Our Case Number: ABP-314724-22

RAILWAY (METROLINK-ESTUARY TO CHARLEMONT VIA DUBLIN AIRPORT)
ORDER 2022

RE: SUBMISSION ON THE METROLINK RAILWAY ORDER APPLICATION IN
RELATION TO AIRSIDE RETAIL PARK, SWORDS, CO. DUBLIN

AN BORD PLEANÁLA REFERENCE: NA29N.314724

<p>TITLE: <b>RAILWAY WORKS METROLINK - PROPERTY DETAILS AIRSIDE SHOPPING CENTRE (SHEET 2 OF 2)</b></p>		
DRAWING NUMBER: ML1-JAI-BOR-ROUT_XX-DR-Y-01024		
DRAWN: TW	CHECKED: MM	APPROVED: PB
SCALE: 1:1000 @ A3	REVIEWED: AS	
AREA NUMBER: 301	PLAN NUMBER: ML-P 301 U-V	SUBJECT: PROPERTY

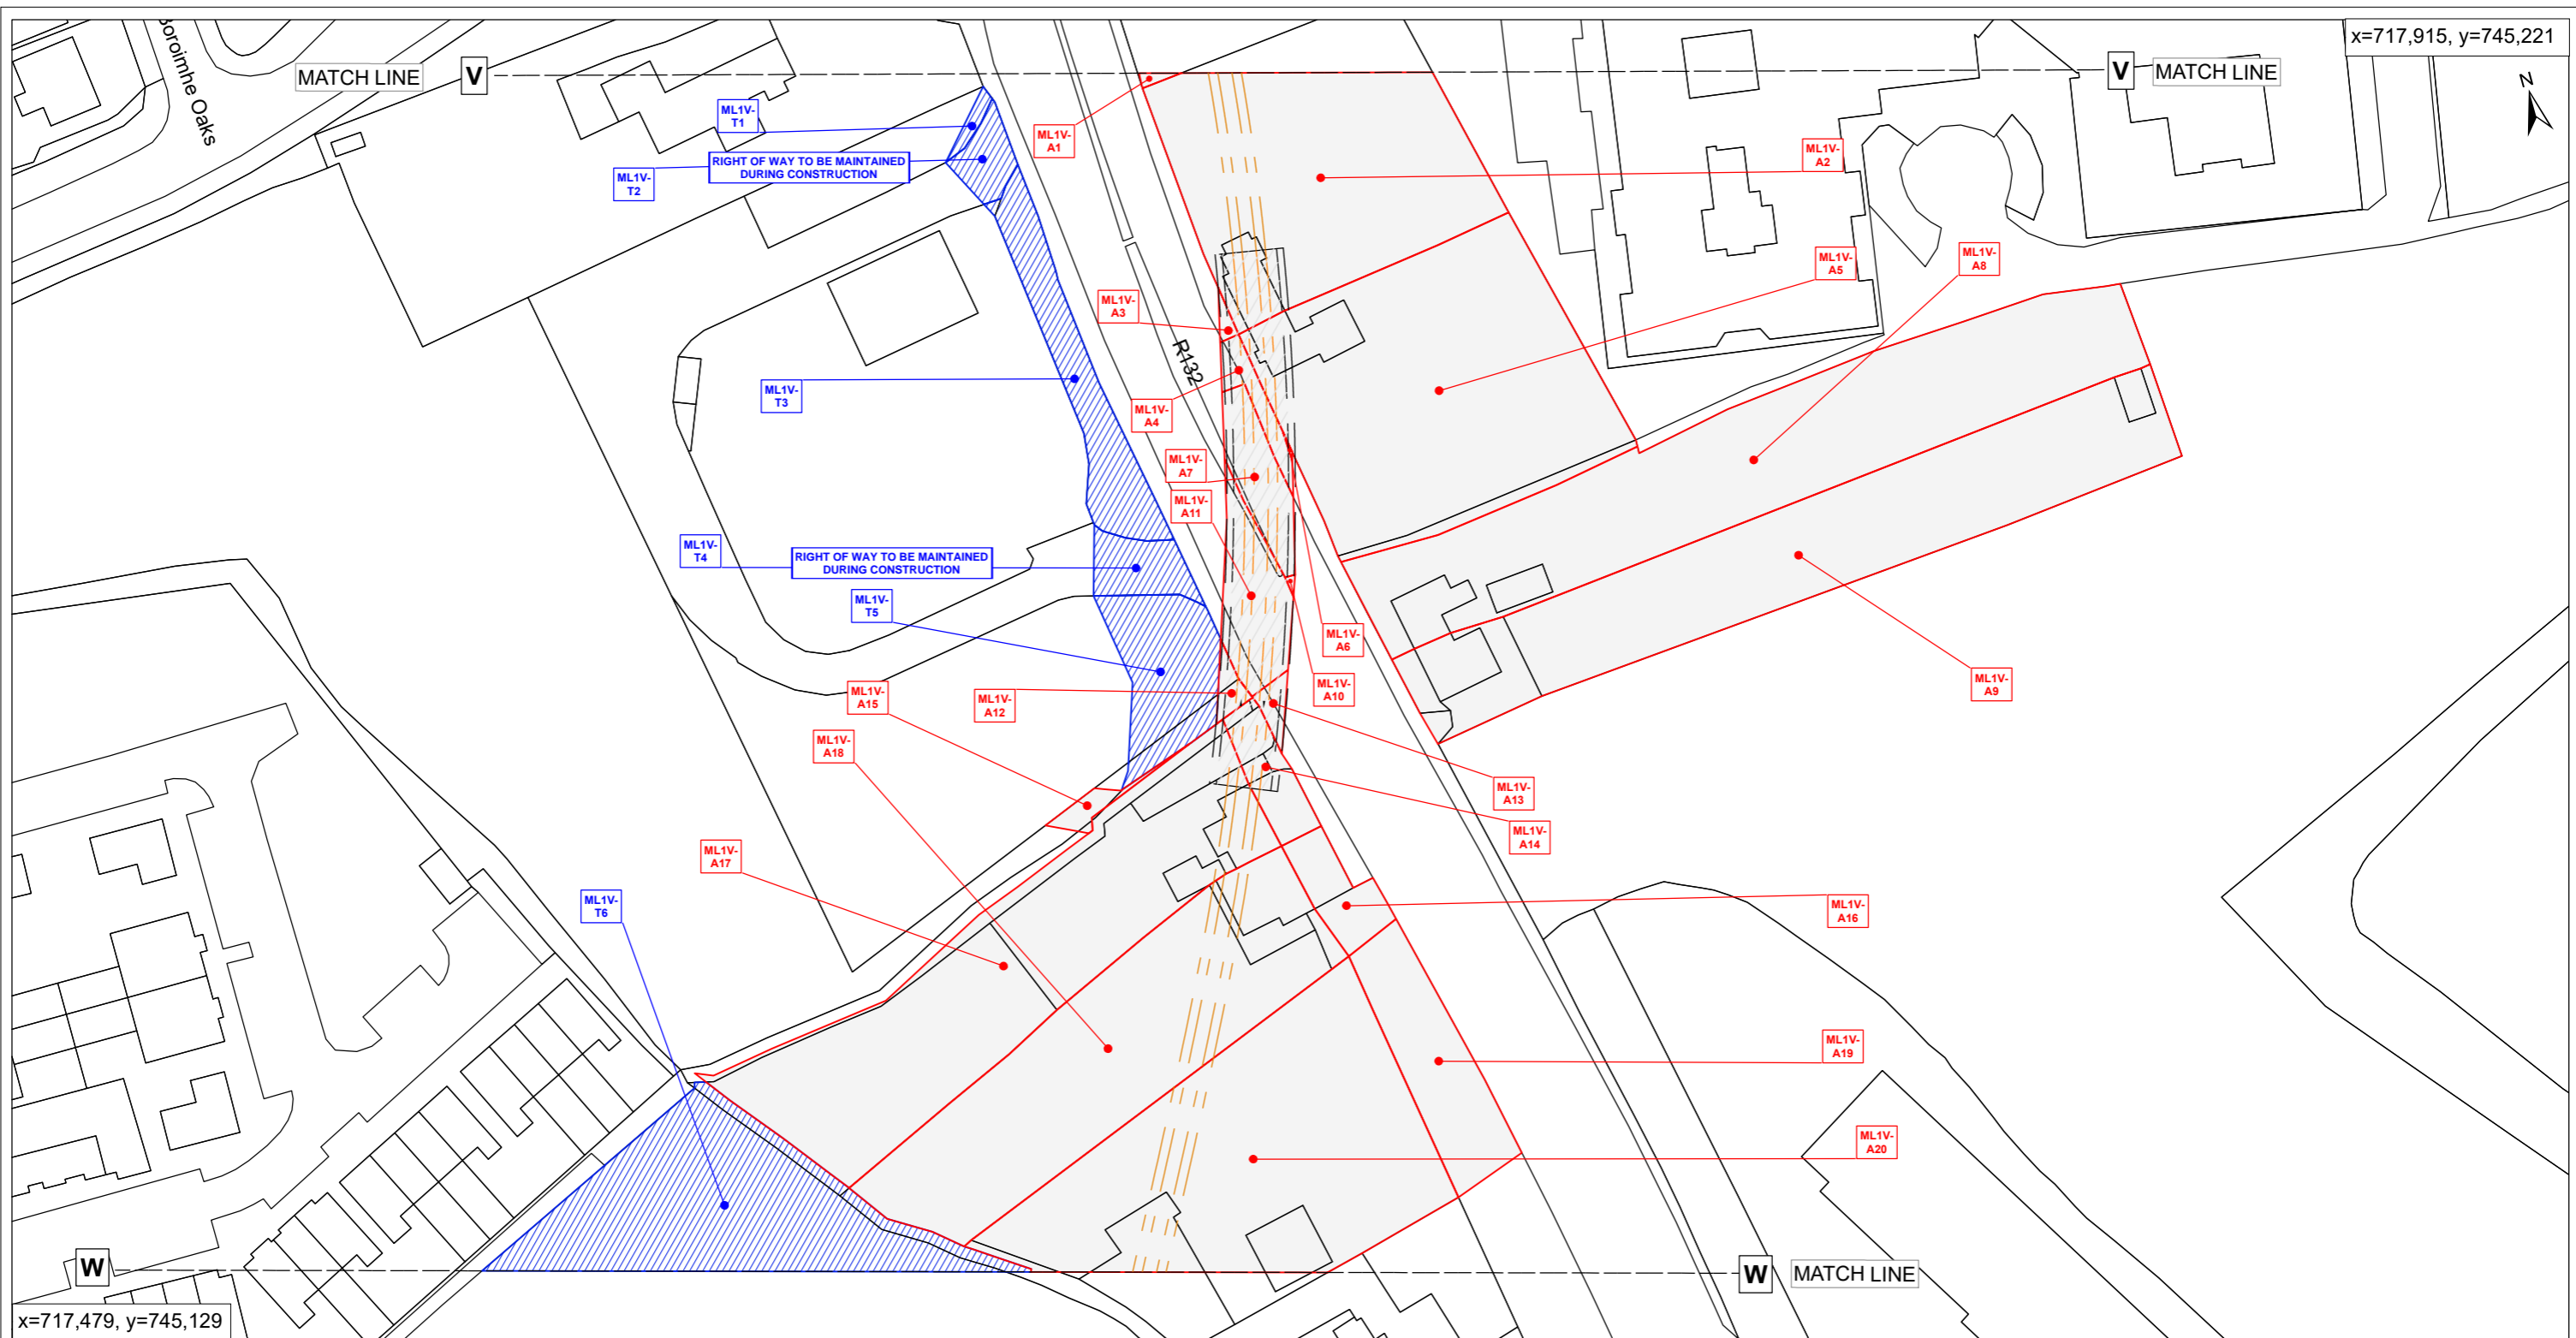
Figure 3: Extract from drawing 'Railway Works MetroLink – Property Details Airside Shopping Centre (Sheet 2 of 2)' – permanent land take in grey, temporary land take in blue, and proposed wayleaves in yellow

The temporary land take indicated includes areas within and adjoining the existing Airside car park.

Wayleaves are also indicated traversing the existing car park, and along an existing access road serving the retail park.

Our clients have concerns in relation to the permanent acquisition of this area of land (ML1T-A8). It is not clear why it is proposed to acquire this area permanently and respectfully requested that this should be omitted from the permanent land take in any approved Railway Order. This area of land (illustrated in Figure 4 above) poses a critical part of the existing infrastructure of the retail park as it is located on the main access route into this area of the retail park and serves a significant existing car park at this location.

This parcel of land should remain in the ownership and control of the owners of Phase 1, Airside Retail Park i.e. IPUT and Irish Life Assurance plc. It is considered that this area of land is not required for the operation of the Metro and that this matter is best addressed extending the right of way/wayleave along the access road into and through this parcel of land leading to the proposed Fosterstown station.

Confirmation is requested that TII and users / passengers of MetroLink only will have the benefit of the rights of way / wayleaves which are proposed at Airside Retail Park (Reference nos. ML1U-W1 and ML1U-W2). It is noted that the two proposed wayleaves include the existing access into the retail park and a further wayleave traversing the existing car park to

Further clarification is required in relation to the likely extent of the use of the existing access into the retail park for which the wayleaves/right way of way is sought (ML1U-W1), as this could have a potential impact on the operation of the retail park.

Additionally, as noted the further proposed right of way / wayleave (which it is understood is intended to facilitate below-ground services and periodic access for works) proposed through the centre of the existing car park adjacent to Unit 1 (ML1U-W2) will effectively bisect this area of car parking instead of following the boundary of the existing car park. It is requested that this alignment of wayleaves/right of way is realigned parallel to the metro alignment as proposed in order to minimise it's potential impact for future disruption to the carpark. This option should be fully investigated by TII.
